Planning Application Ref: FP/180/17/PL (4) Current comments in green typeface

Location : 84 Flansham Lane, Felpham

Description of works: Demolition of 1 No dwelling and erection of 2 No dwellings

Bernie Harverson

Appendix 3

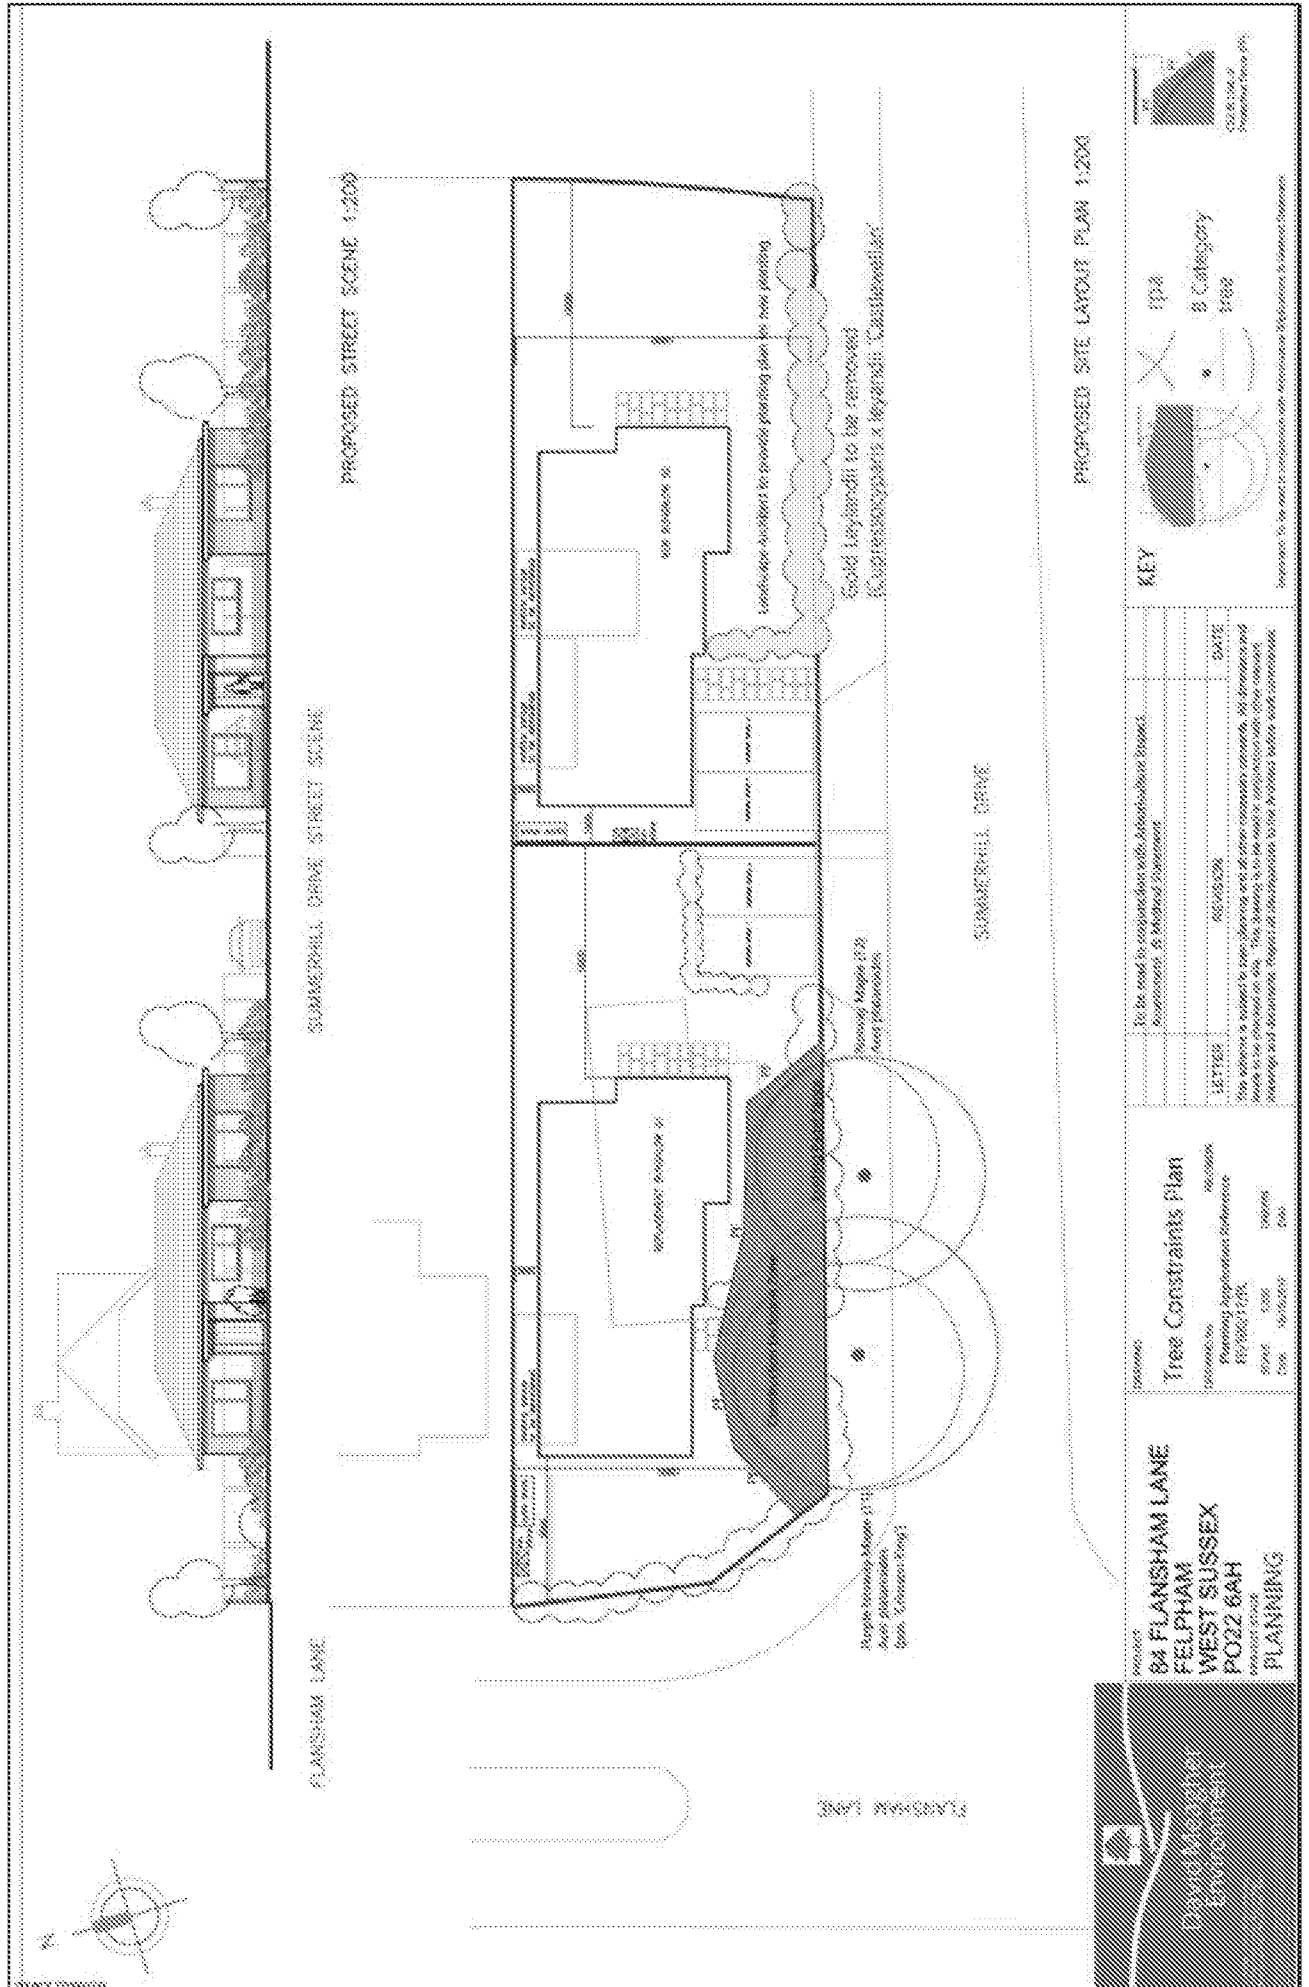
- The applicants have now submitted a combined AIA & AMS report with a Tree Constraints Plan but no Tree Protection Plan prepared by David Meagher Environment Consultants. The Tree Survey/RPA Schedule conforms to BS5837 requirements and is sound and I agree with the data and gradings with the exception of the life expectancy of these trees which I place at over 40 years.

- Their report says that ‘ The survey reveals that the trees either above or below ground will not interfere with site works to demolish the existing bungalow and erect two new single storey dwellings.’ I fundamentally disagree with these conclusions since their survey data and constraints plan show both a canopy overhang of the existing building as well as a significant overlap of the RPA of the existing building. What I wanted to see was how they would demolish the building carefully pulling it in on its own foot[print away from the trees and then once they have exposed bare earth erect protective fencing at the full distances specified in their schedules or lay ground protection etc etc – this is not advocated in their AMS so I cannot accept it.

16.0 Tree Protection plan (see also stand alone copy) FP/180/17/PL

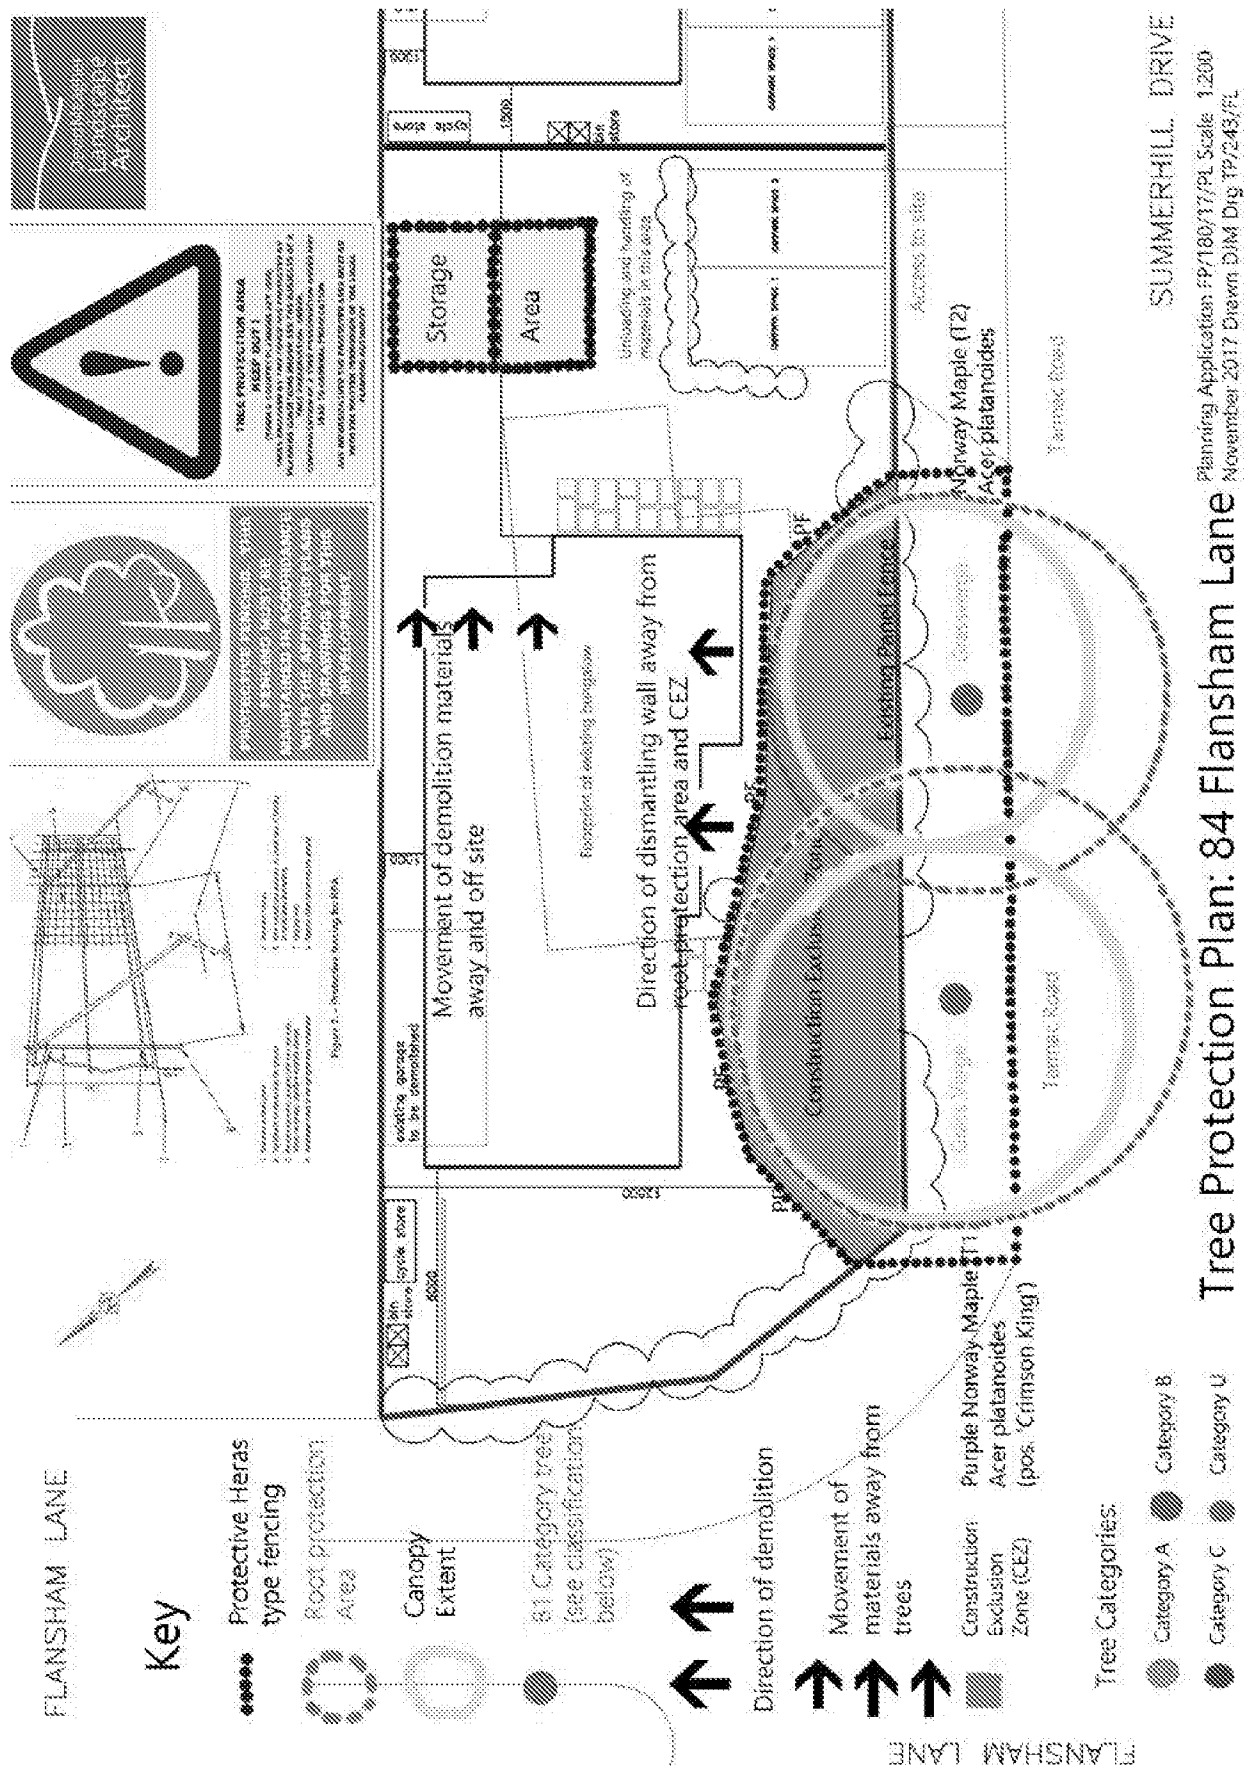
- The applicants have now supplied a revised AMS report and TP Plan which reads well apart from one paragraph which will need to be amended regarding machinery access within the RPA.

- I now recommend a TPO is made to protect these trees – see attached TEMPO forms.
 - I am not satisfied with the AMS report as it is vague and not detailed enough with respect to protection measures to ensure that these two trees survive the demolition and construction process so I sustain my OBJECTION and stand by my recommendation that these two trees be TPO'd.

- I am certain that this site can be developed with these trees in situ but I will need to see a supporting and detailed AMS report and Tree Protection Plan before I am prepared to recommend it for approval.

- I now recommend APPROVAL for this scheme based on the latest revised submissions and subject to the amendment of the Machinery paragraph on Page 17 and the application of the following standard Conditions :-

1. All demolition & construction works are to be carried out in strict accordance with :- **Arboricultural Method Statement Report Ref: AIA&MS Version 2 Nov17 and Tree Protection Plan ref: DJM TP/243/FL November 2017.**
